Addendum No. 1

RE: Contract ID: C202303

Martin County (R-5124)

US-64 From Edgecombe County Line to US-64 Alternate

PROJECT NO.	SHEET NO.	TOTAL NO.
R-5124	3	3

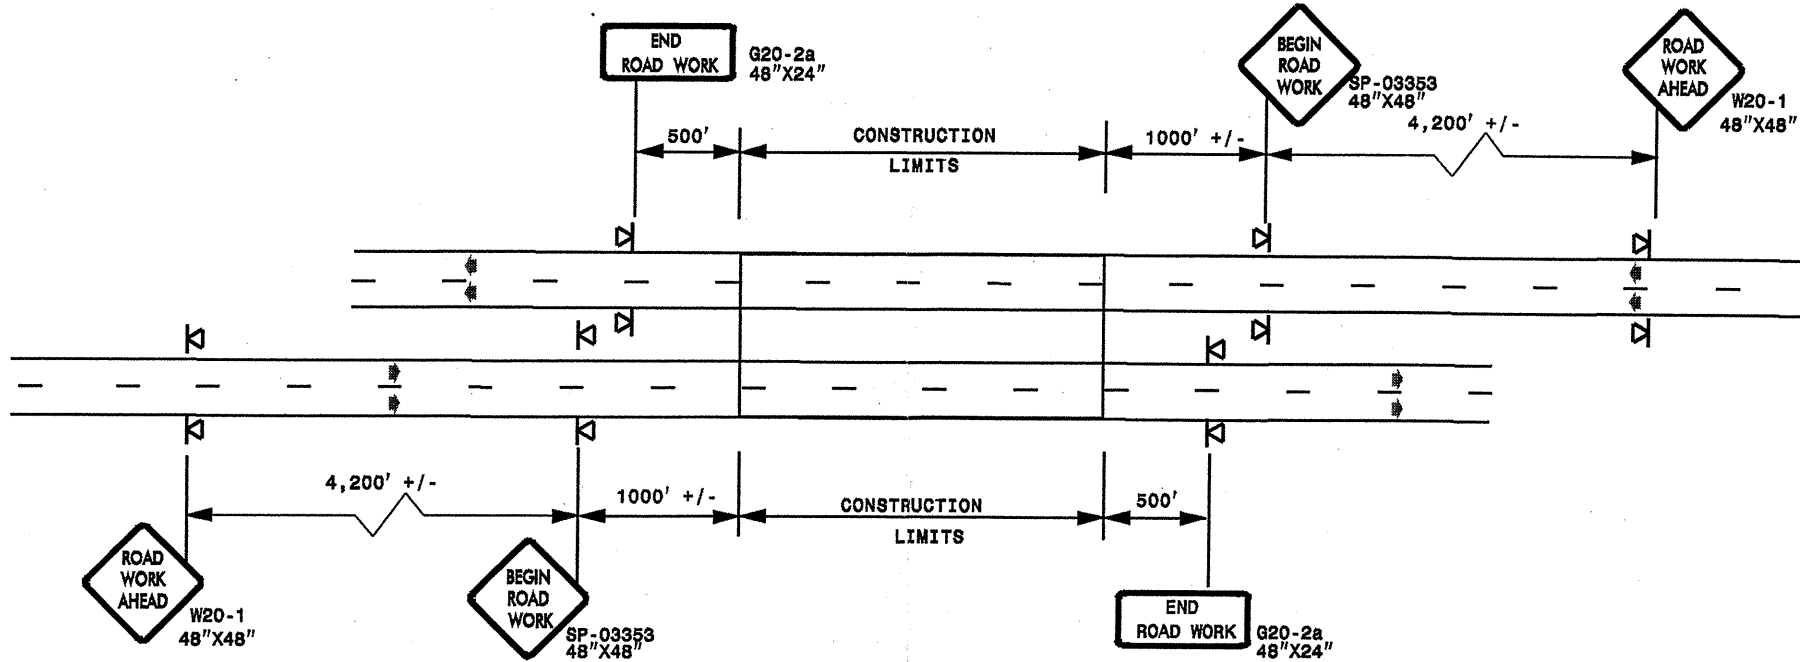
On Sheet No. 3 the quantity for "Shoulder Reconstruction" and "Seeding and Mulching" has been revised. Please void Sheet No. 3 in your sketch maps and staple the revised Sheet No. 3 thereto.

On Page No. 1 of the item sheets, by copy of this addendum the quantity for line item "3-1245000000-E-SP Shoulder Reconstruction" has been reduced from 73.6 SMI to 60 SMI. On Page No. 2 of the item sheets, by copy of this addendum the quantity for line item "17-6084000000-E-1660 Seeding and Mulching" has been reduced from 36 ACR to 30 ACR. The contractor's bid must be based on these revised pay item quantities. The contract will be prepared accordingly.
